EL PASO COUNTY STORMWATER MANAGEMENT PLAN CHECKLIST

Unresolved checklist item:
 Include contact info for all
 of these people or
 placeholders if TBD

**WELL NO. 22 TRANSMISSION LINE PLAN**

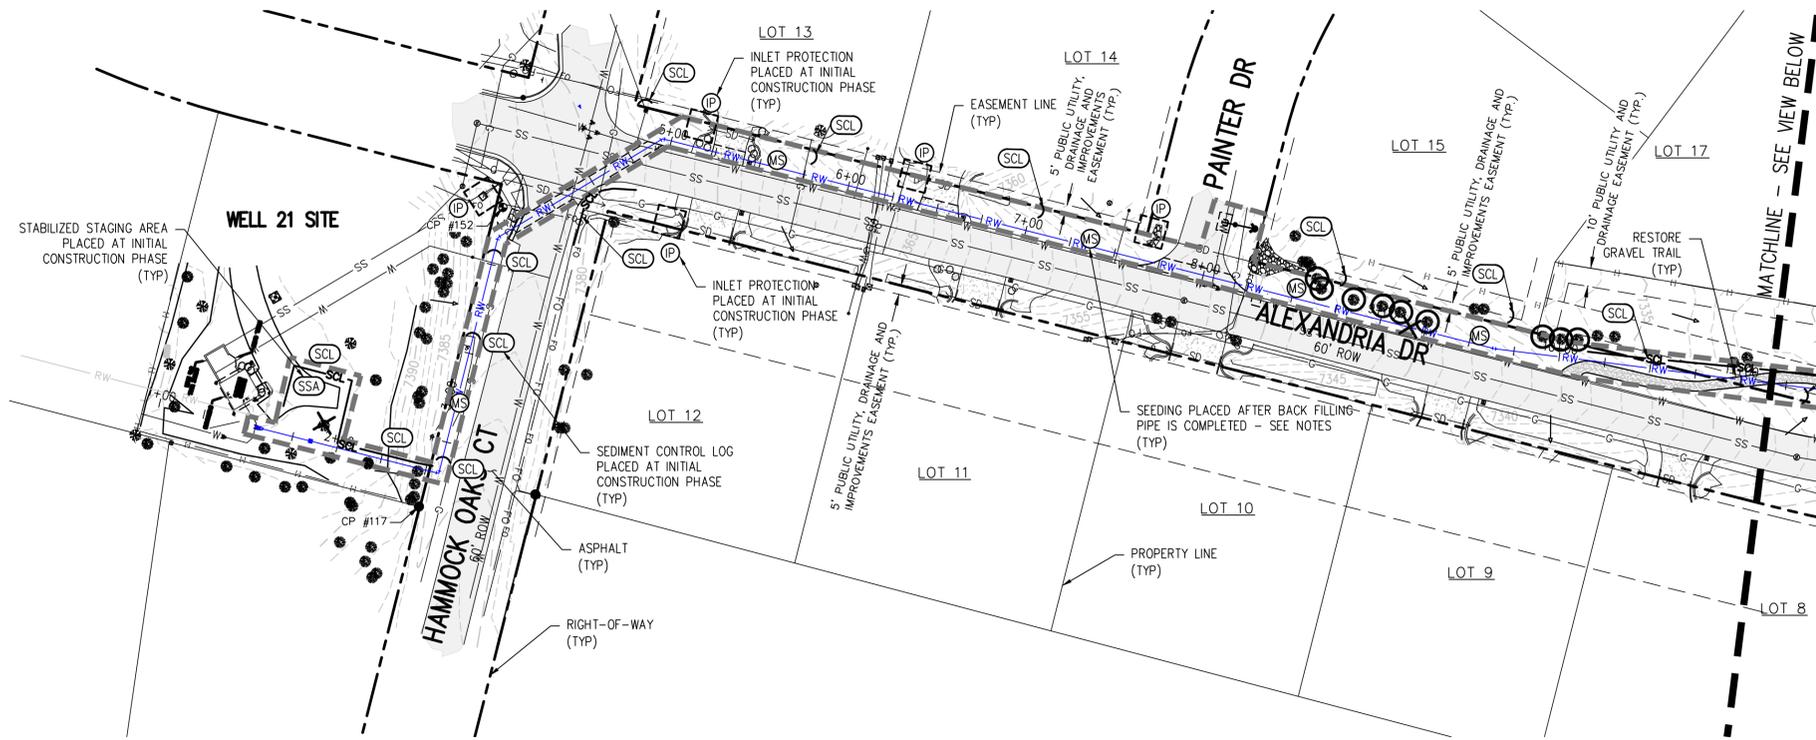
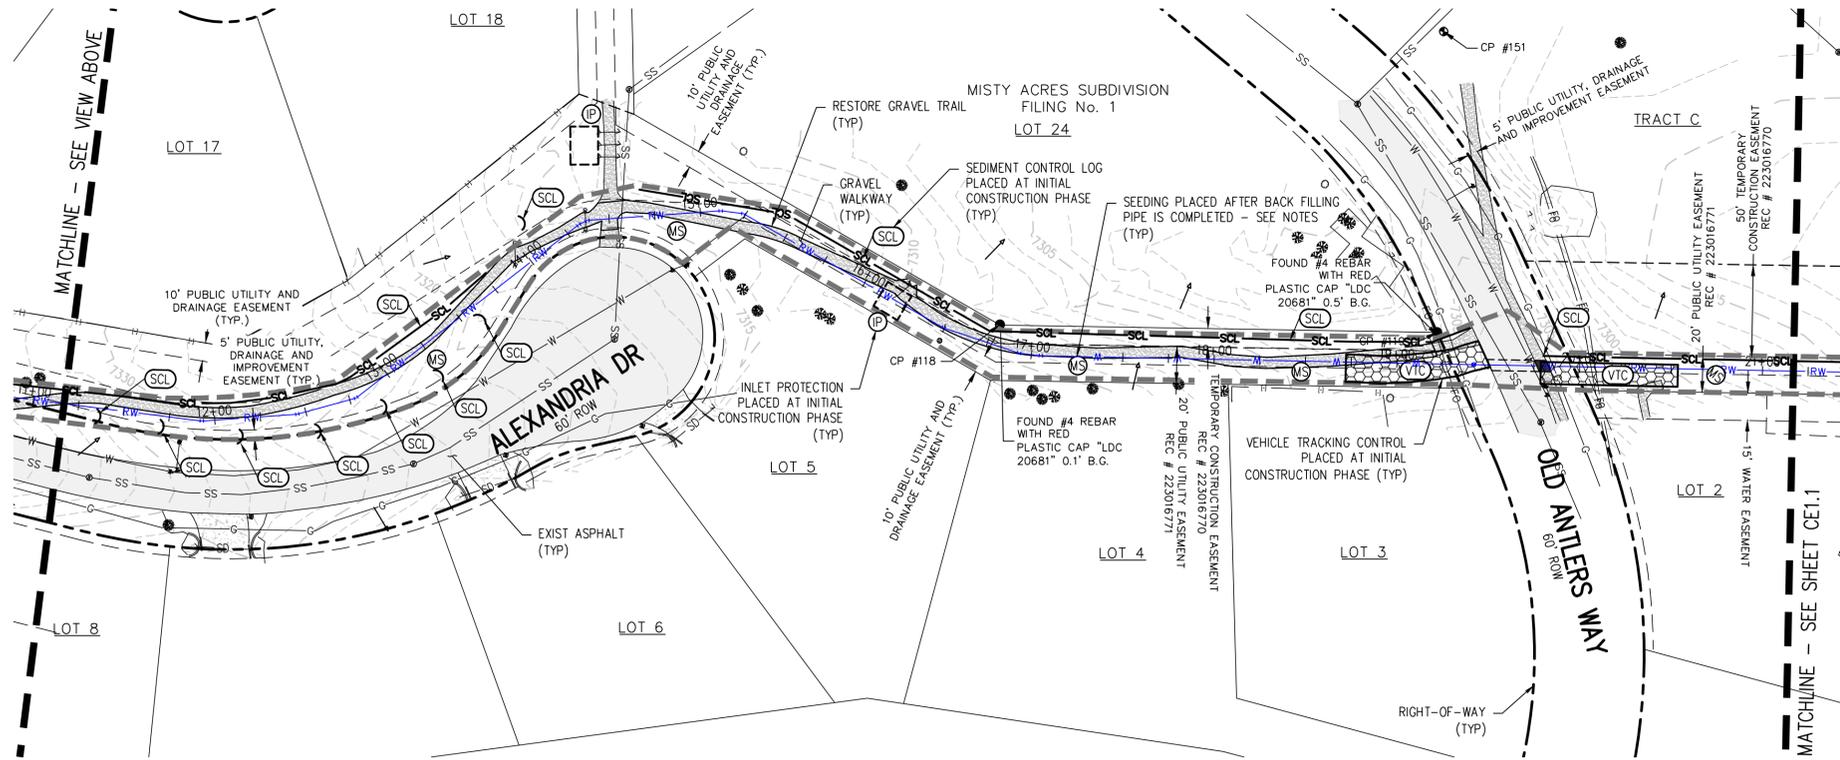
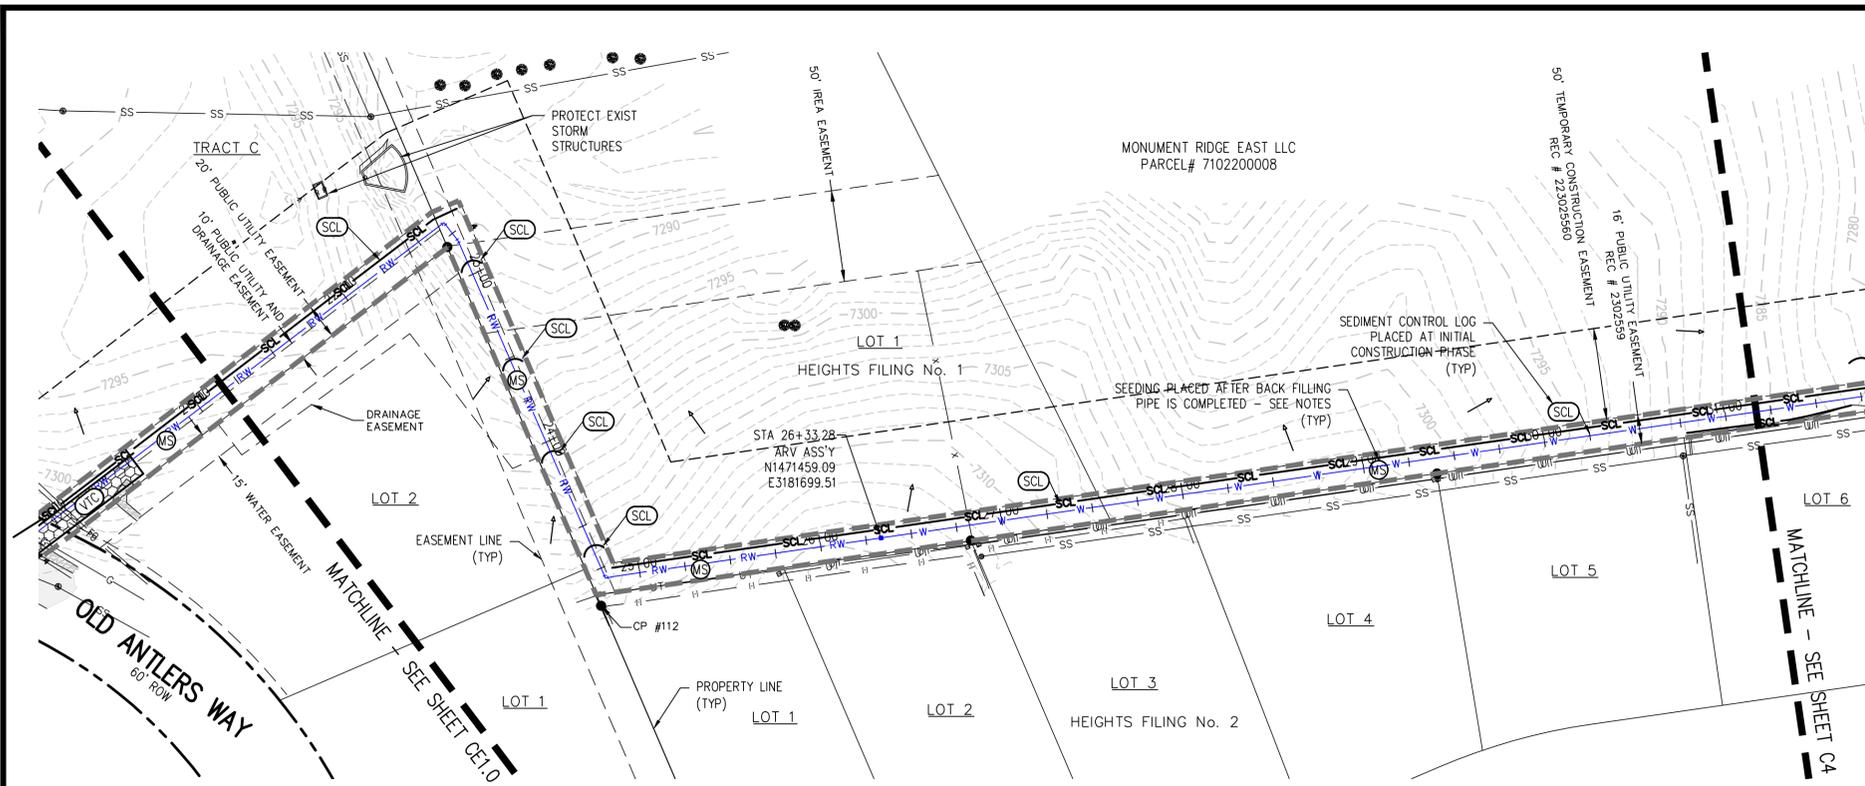
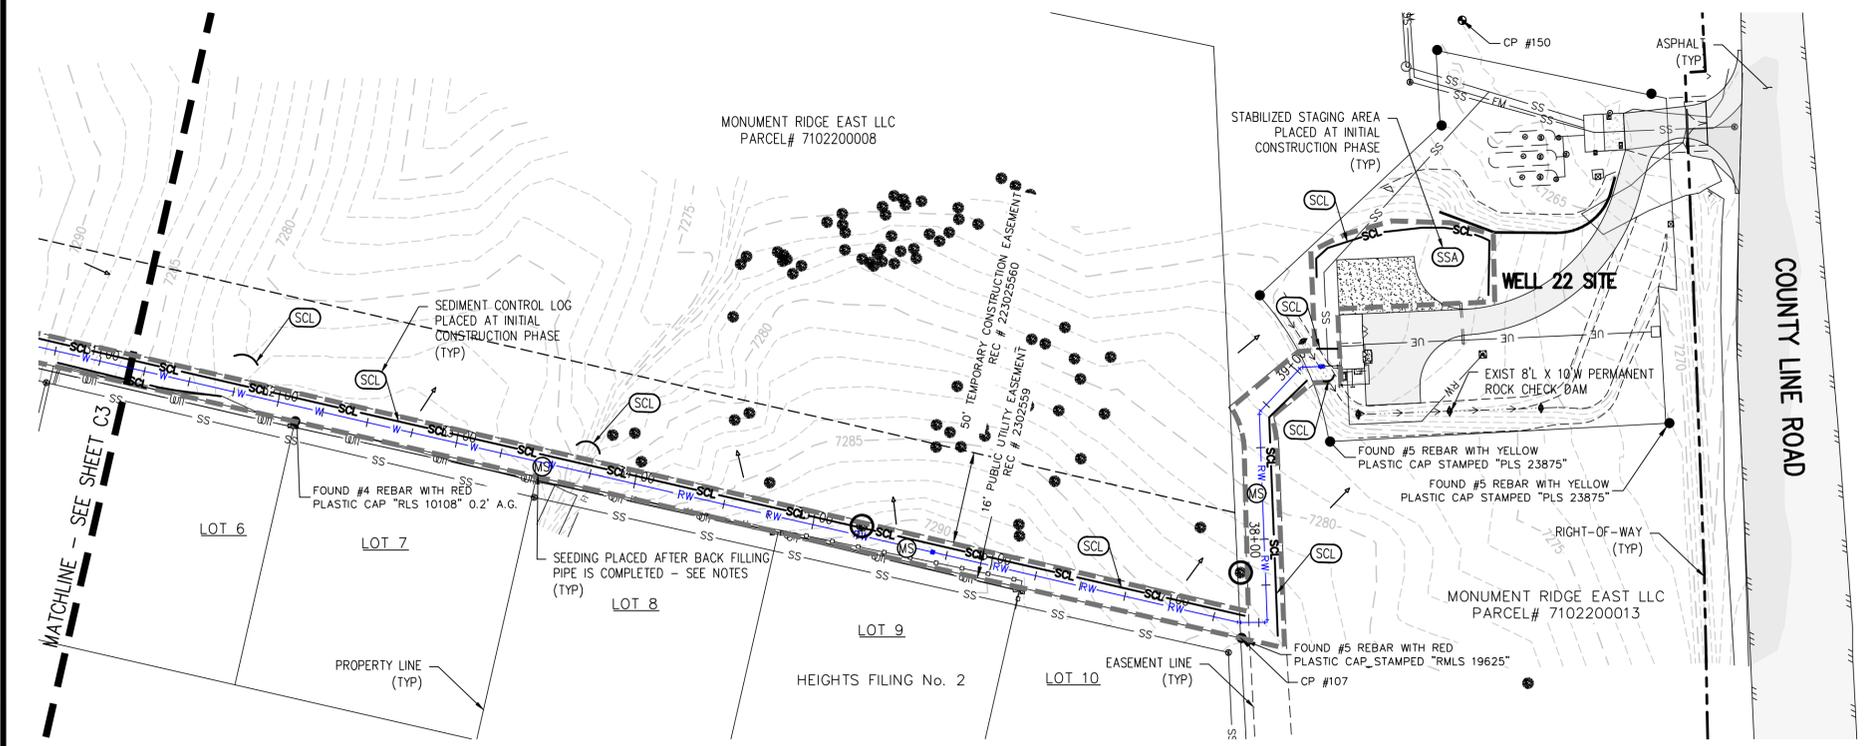
Please make sure that these two items are addressed explicitly. I am not seeing them on Sht CE1.2
